# CITY OF ALBUQUERQUE

Re: Certification Submittal for Final Building Certificate of Occupancy for  
Carl's Jr, [C-12 / D2F]  
8641 Golf Course Rd. NW  
Architect's Stamp Dated 02/10/06

**Re: Carl's Jr., 8641 Golf Course Rd. NW**  
**Grading and Drainage Plan**  
**Engineer's Stamp dated ~~10-25-05~~ (C12-D2F)**

**Re: Carl's Jr., 8641 Golf Course Rd. NW, Grading & Drainage Plan  
Engineer's Stamp dated 7-11-05 (C12-D2F)**

**CARL'S JR. GOLF COURSE RD. GRADING AND DRAINAGE PLAN**

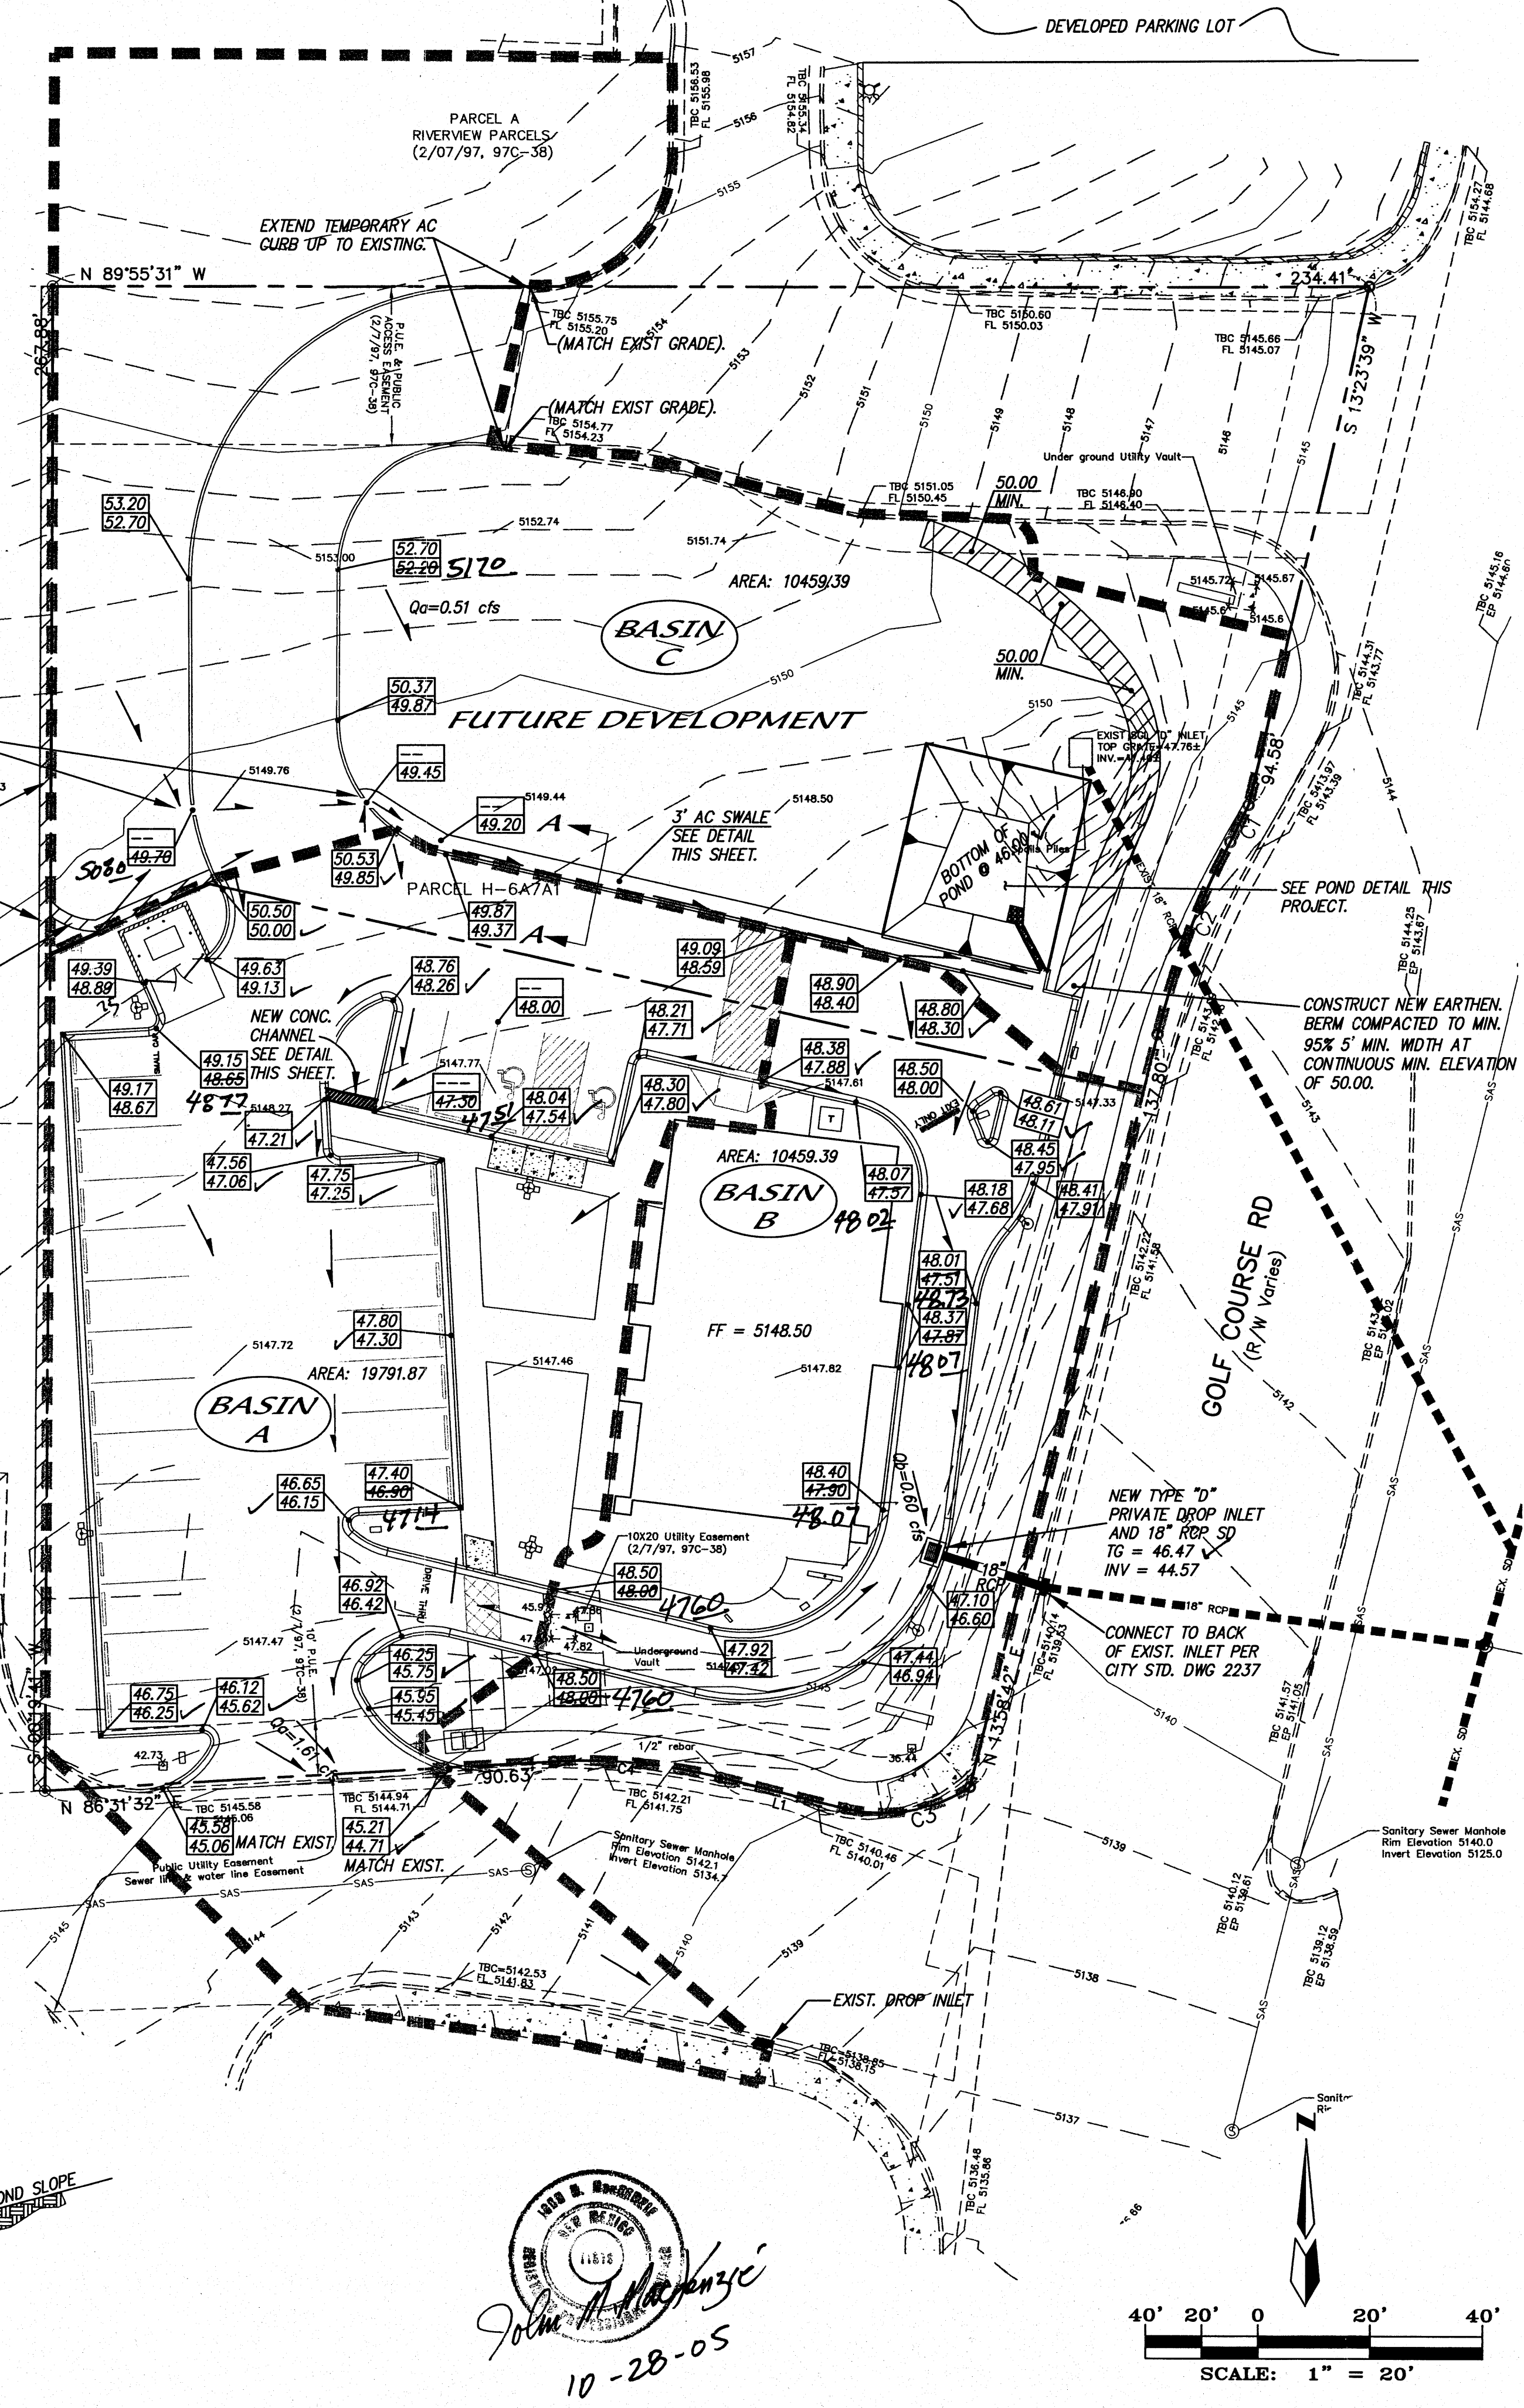
- Provide cross-lot drainage easement.
- Call out City of Albuquerque Standard drawing number for the proposed Type "D" drop inlet.
